EP/30/26/HH 3, Boundary Way Side extension and rear extension

I write on behalf of the East Preston & Kingston Preservation Society to object to some aspects of this application. The plans submitted, and proposals for materials, are inaccurate, making our judgement on this submission challenging.

GROUND FLOOR PLAN

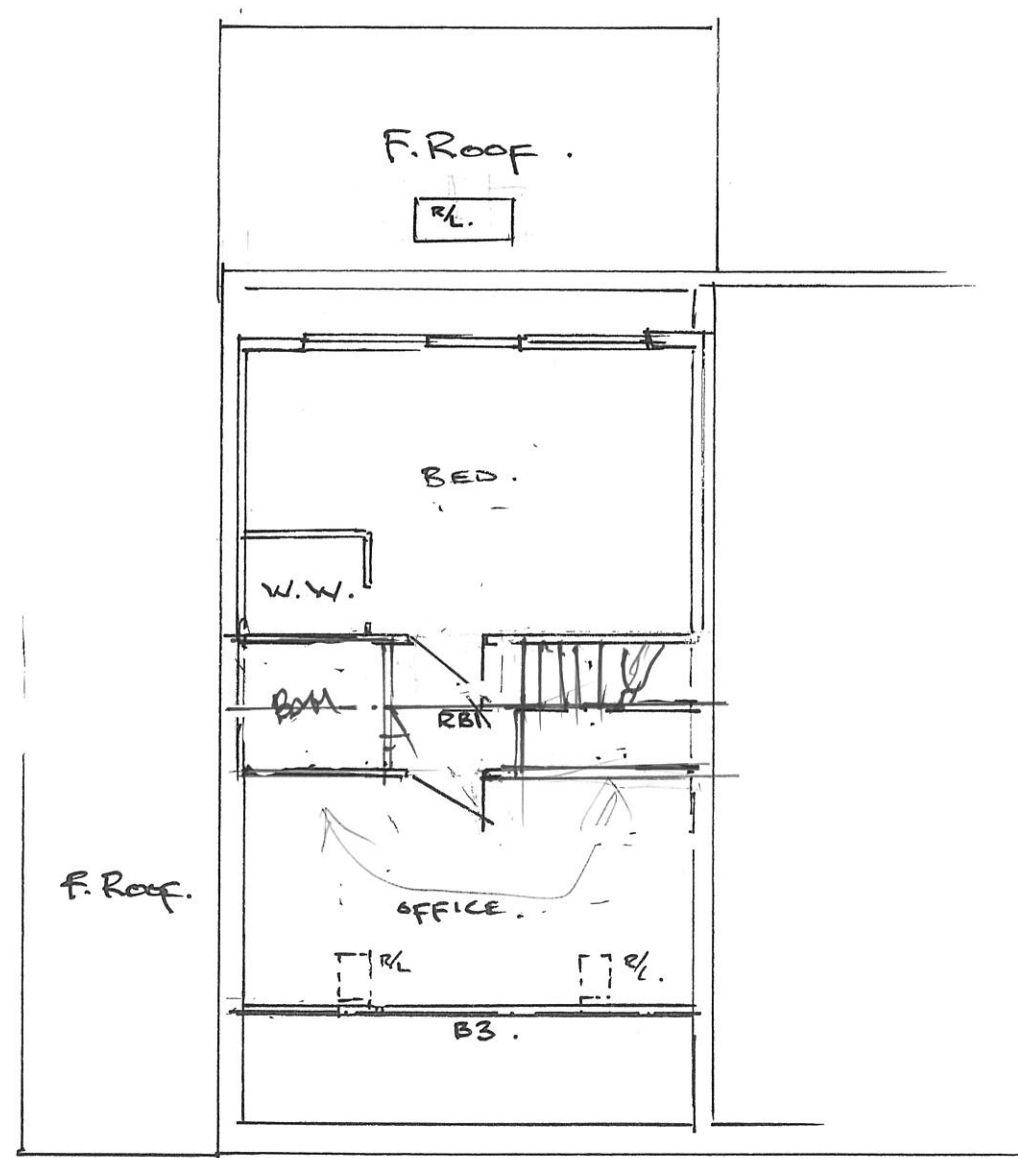
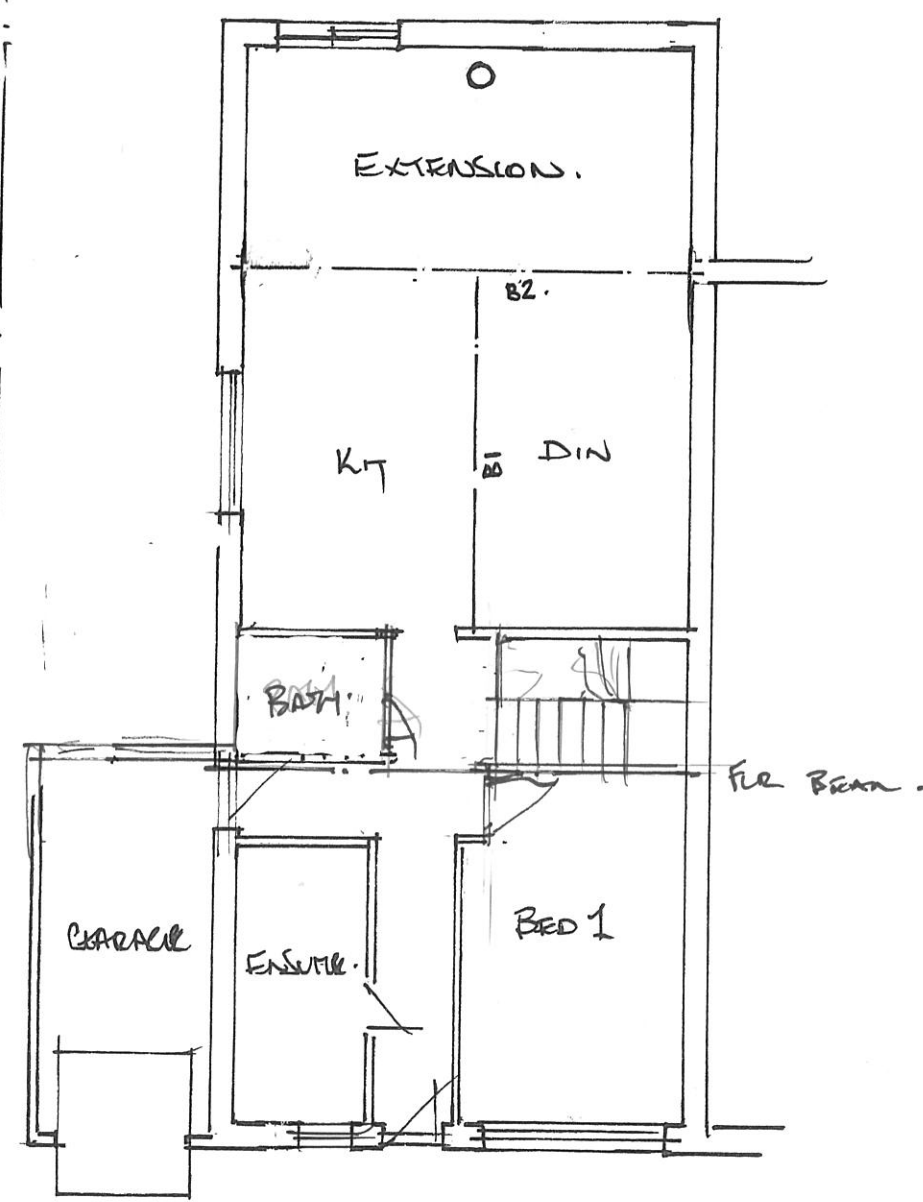
Amended ground floor “proposed” plan shows no access to the first floor, where a dormer is currently being built under Permitted Development regulations. The superseded “proposed” plan does show such access, so we assume there is such a stairway.
